RFI

RFI #: 119  
 Date: 5/17/2012  
 Job: EB-02 Keller Springs Lofts  
 Phone: 877-777-5115

Subject: Reinforcement Between Garage and Elevator #2

SHEET NUMBER
S2.14P

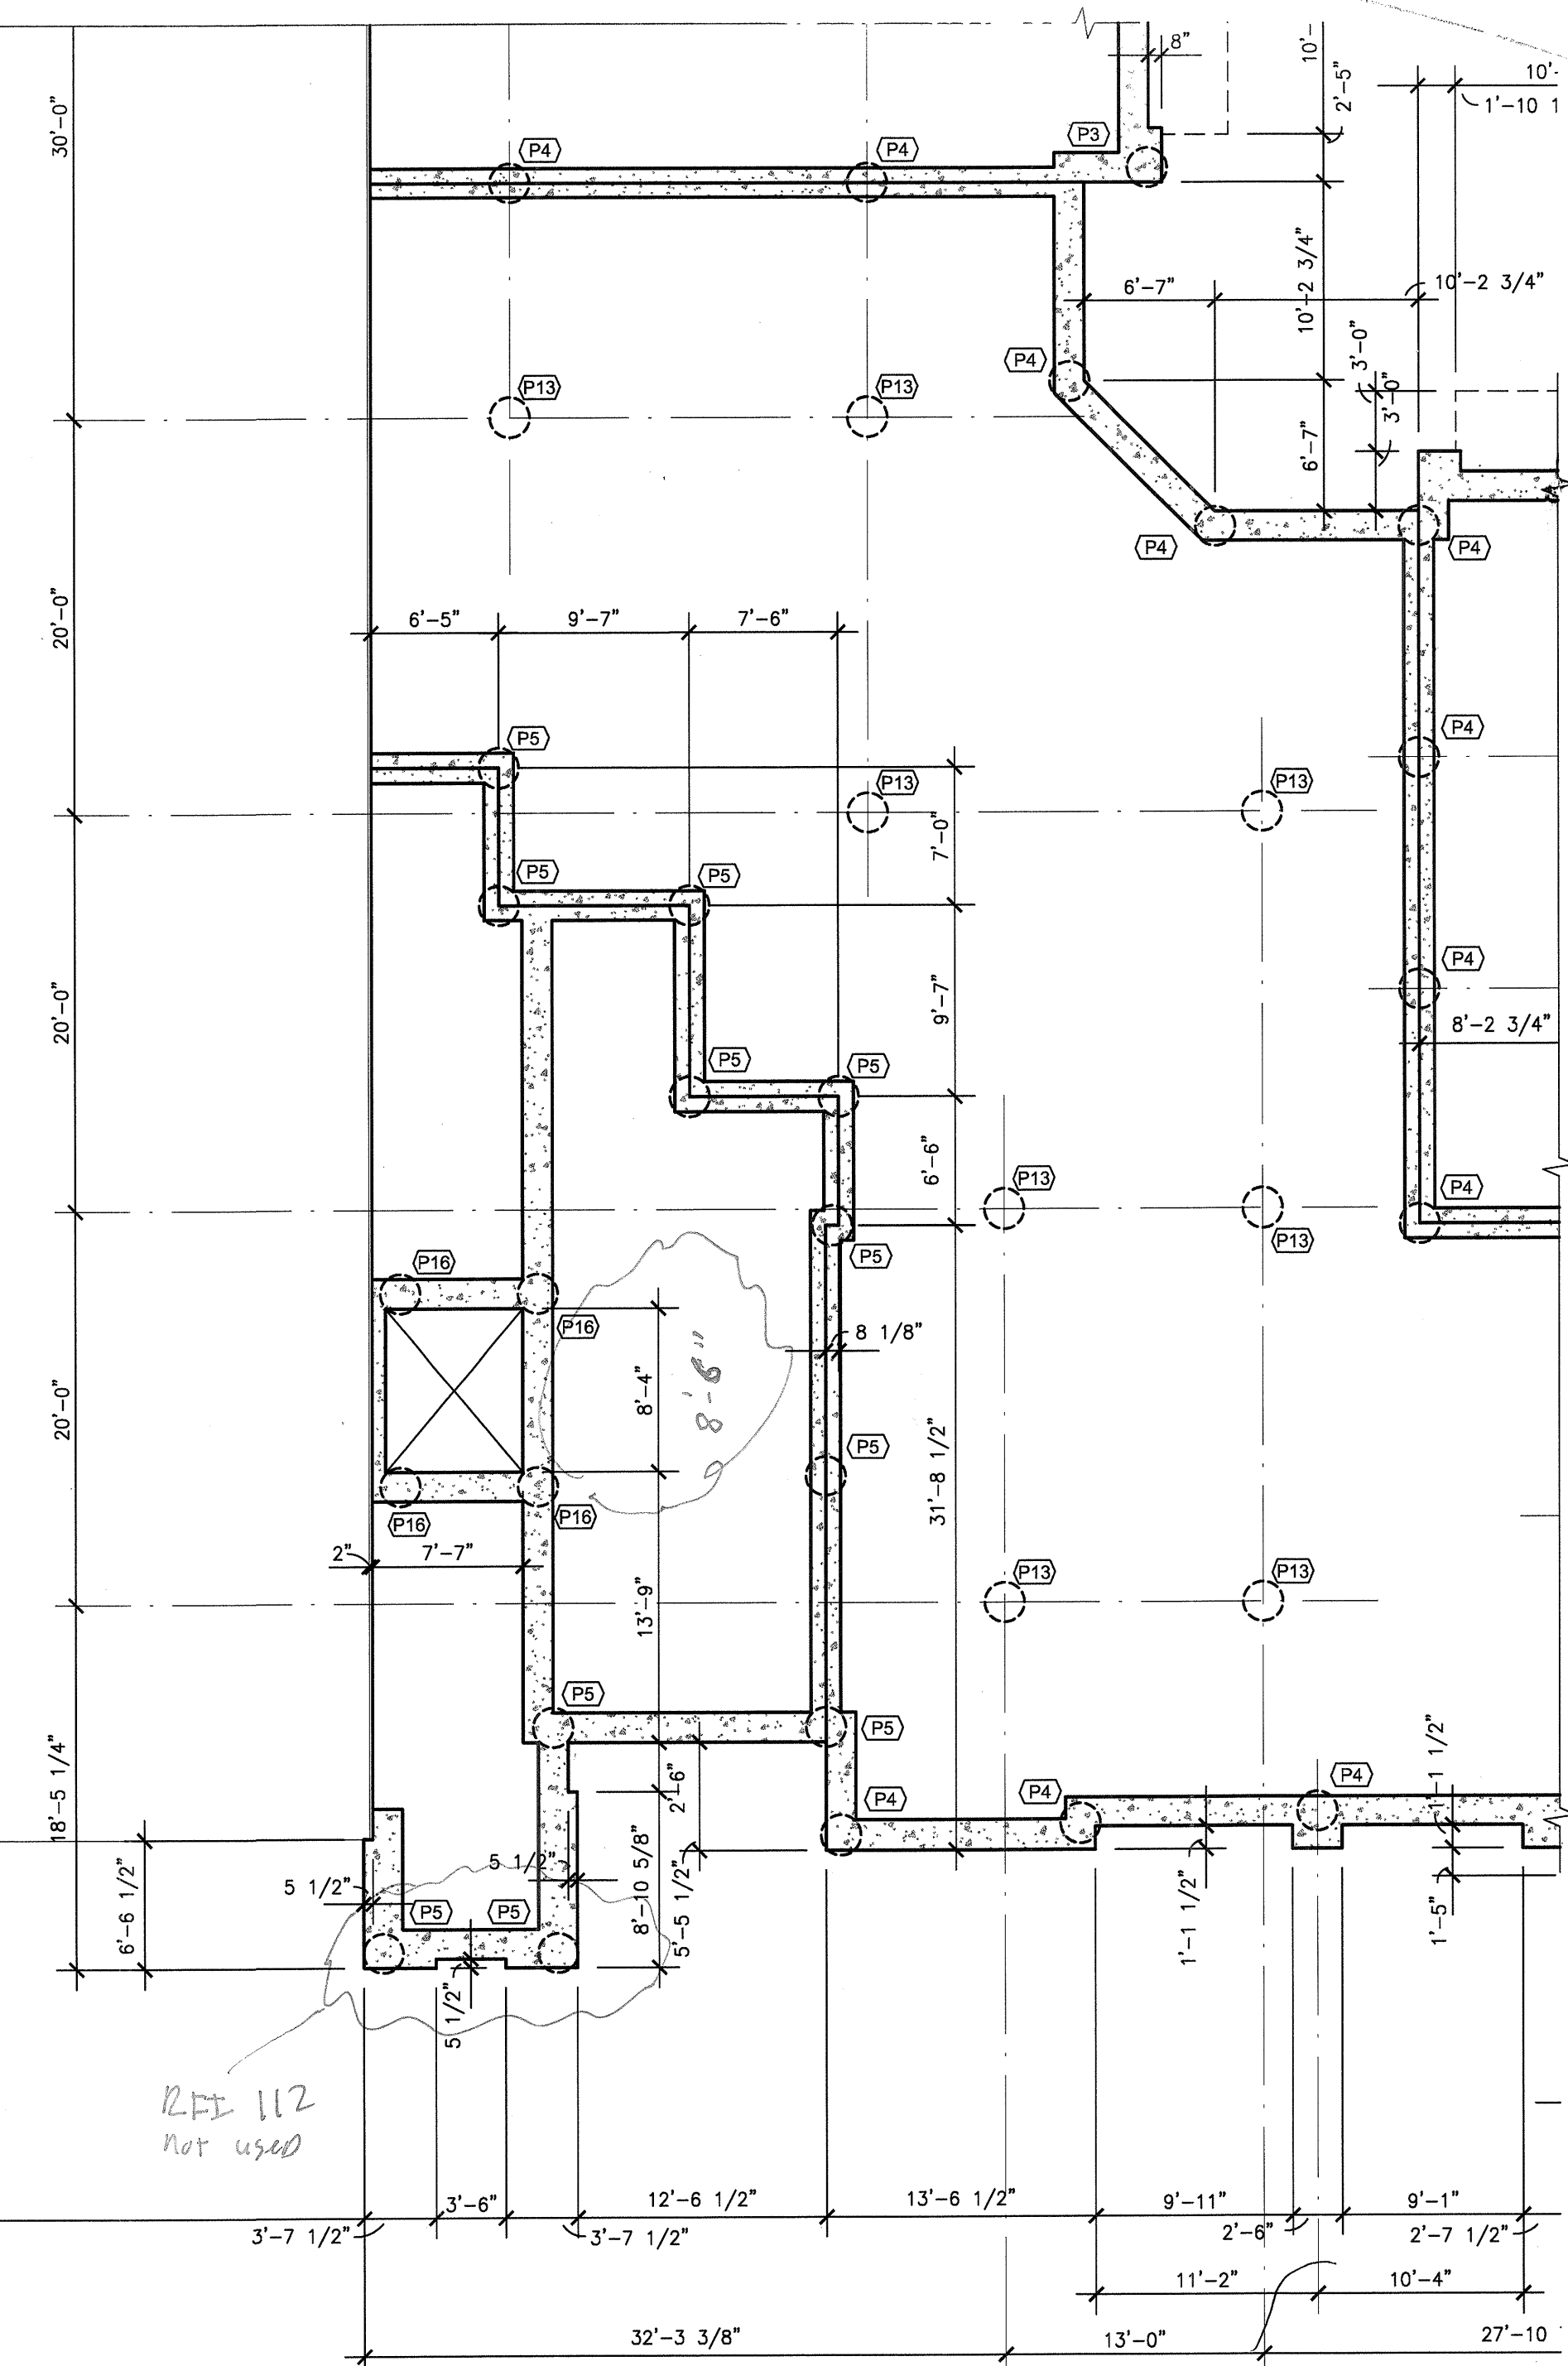
**Request:** Date Required: 5/18/2012  
 There isn't a cut through the area between the garage and elevator pit #2. There will be an 8" wide slab between the garage and the elevator pit wall that supports the elevator shaft wall. Does that area need some other type of support than just a couple of #4 bars?

\*Refer to PPO Response to RFI 122 on May 25, 2012.  
 \*If you have questions or require additional information regarding this matter, please do not hesitate to contact us.

**Request:** Date Required: 5/24/2012  
 Please provide a detail sketch showing the proper number and placement of dowels to tie the elevator back wall into the beam wall of the garage. S2.14 shows using 11/S3.03 at the NW & SW corner of the pit adjacent to the garage. Please provide a sketch for clarification purposes on the elevator wall butting into the garage.

\*\*While on site on Thursday, May 24, it was observed that the concrete subcontractor had drilled and epoxy grouted #4 dowels at approximately 18" o.c. horizontally and vertically in the garage foundation wall to tie into the elevator pit wall. He was preparing to install 2-#4 dowels at 12" o.c. vertical in the garage foundation wall to tie into the intersecting elevator pit walls. Refer to the attached photo. The proposed solution is acceptable to PPO.

\*\*It was also discussed while on site that the 8" wide elevator pit wall adjacent to the garage foundation wall shall be reinforced with #4 bars at 12" on center, each way, and centered in the wall.

**Request:** Date Required: 6/22/2012  
 S2.14 calls for #5 bars at 12" O.C. each way top and bottom on the Pour 21 slab. We plan to chair the lower mat at 3.5" from the bottom and about 7.5" for the top mat. Please confirm that this is acceptable.

Provide chairs to provide 1 1/2" of clear cover between the outer layer of reinforcement and the edge of concrete as noted in Structural Concrete Note #4 on sheet S1.01.

DATE	08-05-2011	SHEET NUMBER	3.1
PROJECT	11129

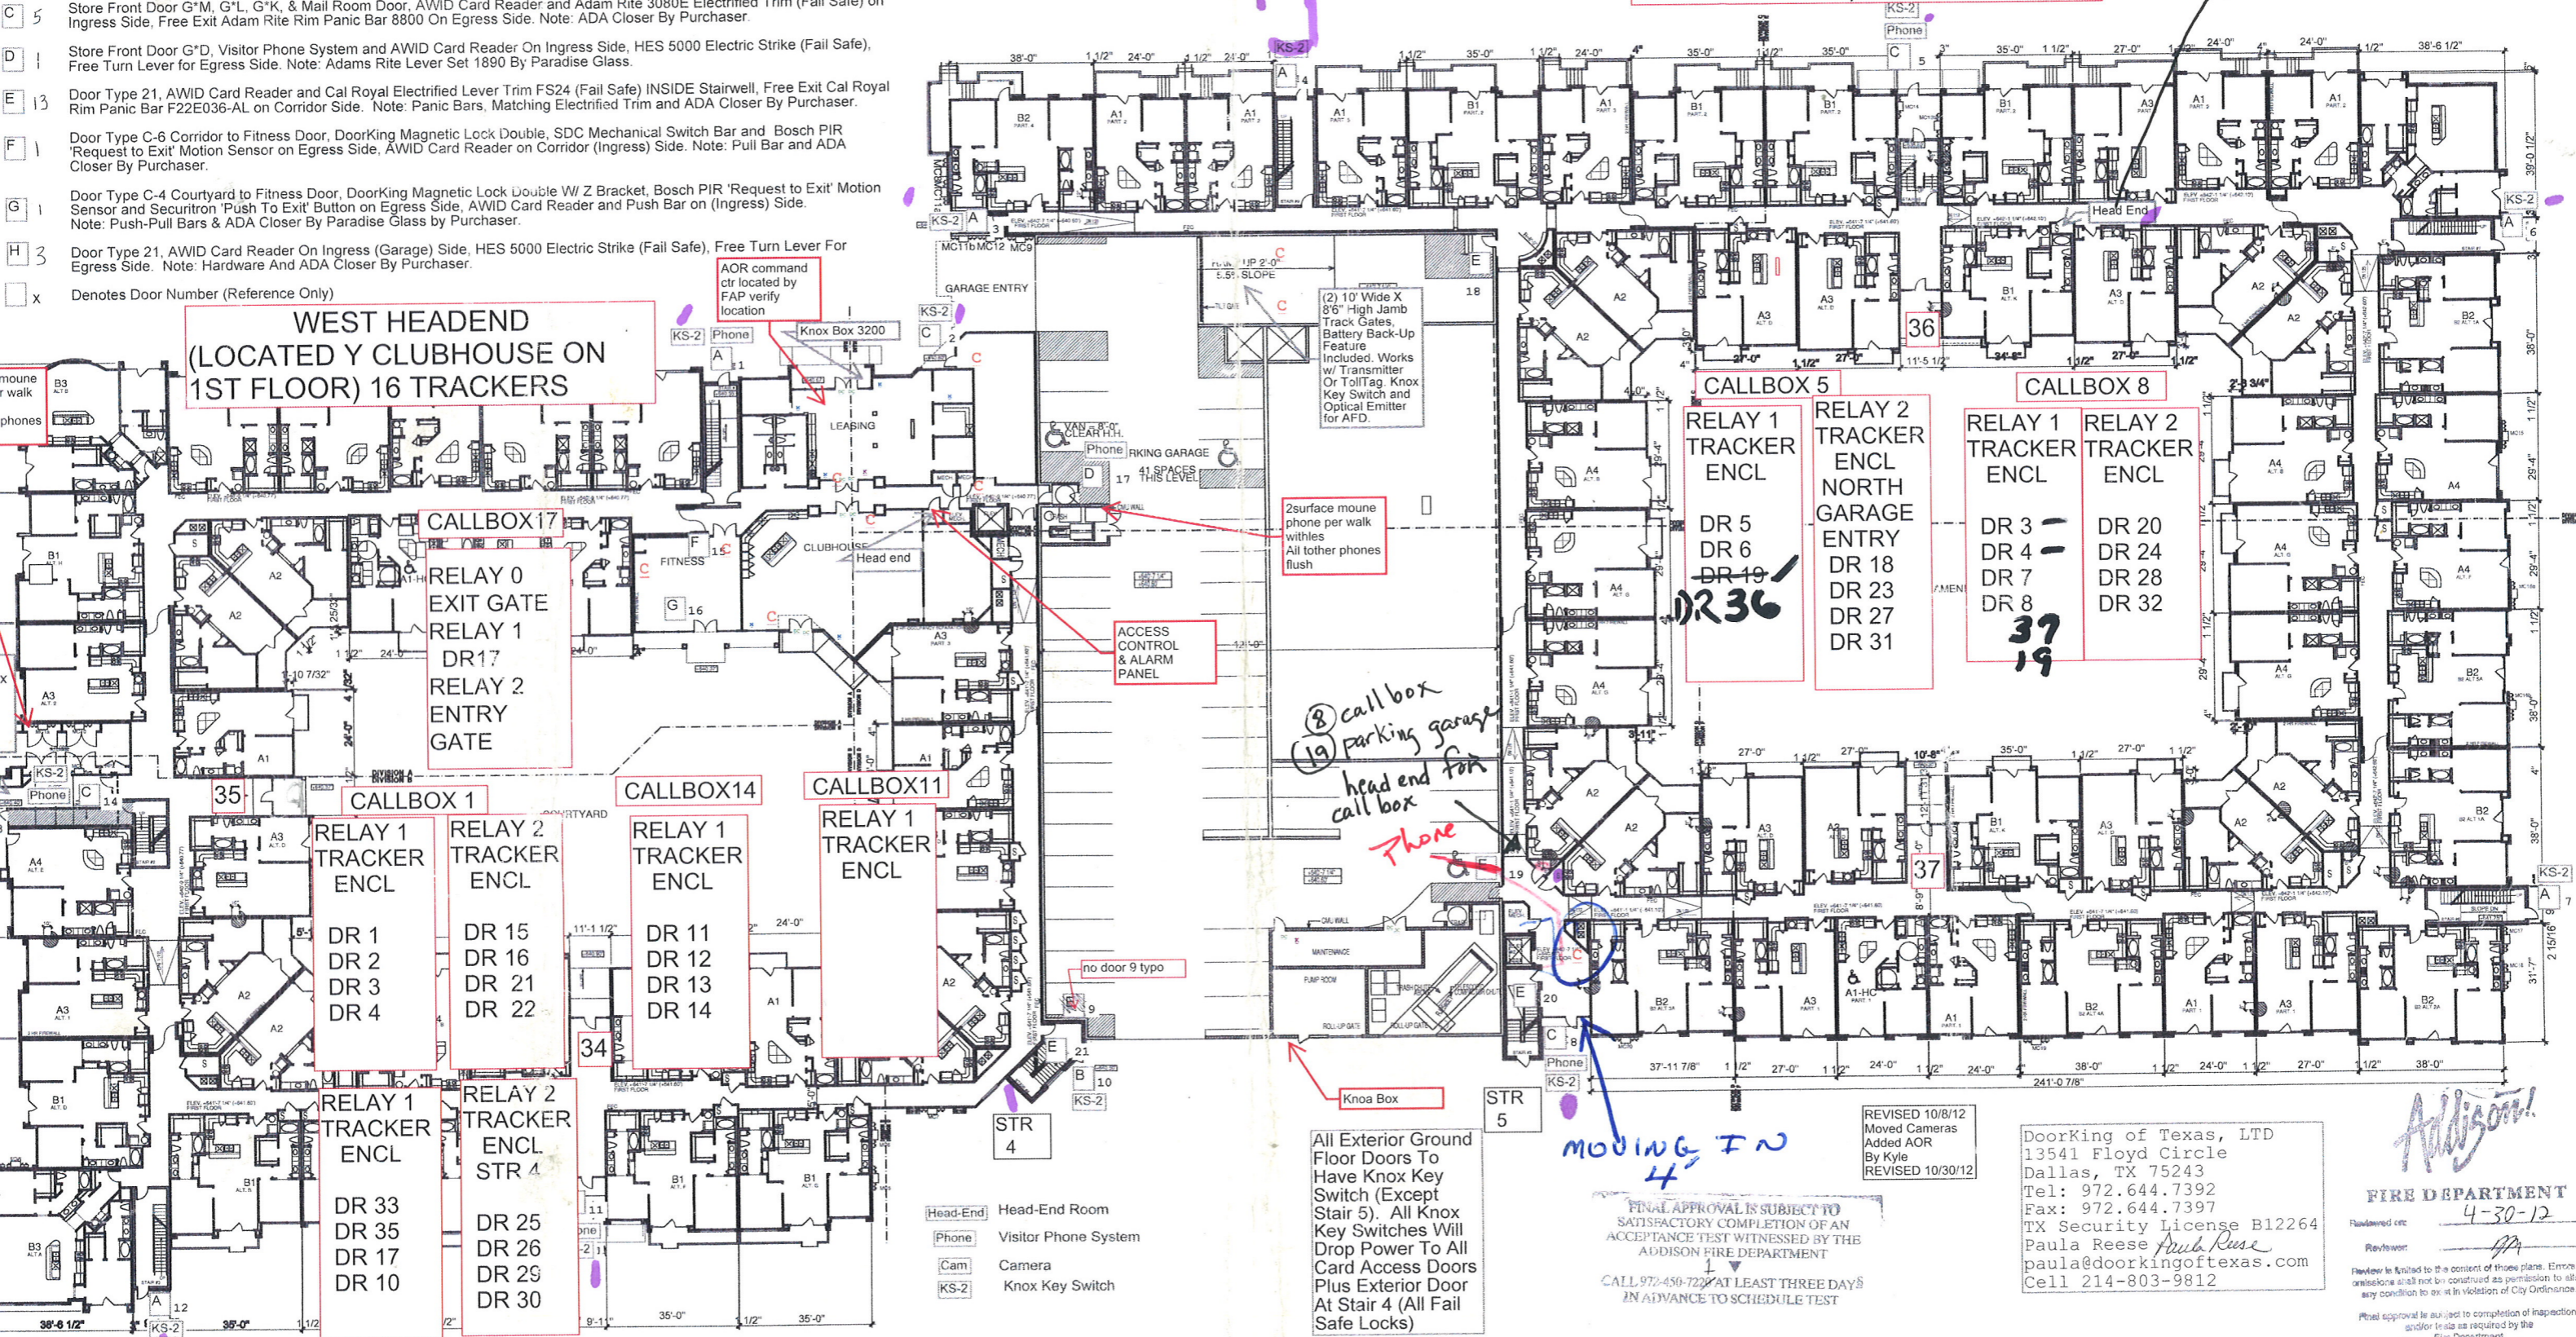
**Request:** Date Required: 3/7/2013  
 S2.1 shows the north horizontal line of the new grade beam at the north side of the mechanical shaft as being 26'-6 1/2" off exterior wall. Sheet 3.1D shows the dimension from the exterior wall to ramp is 26'-3". Does this mean we have to cut into the ramp about 3" for the beam placement?

No. Align new grade beam with edge of ramp.
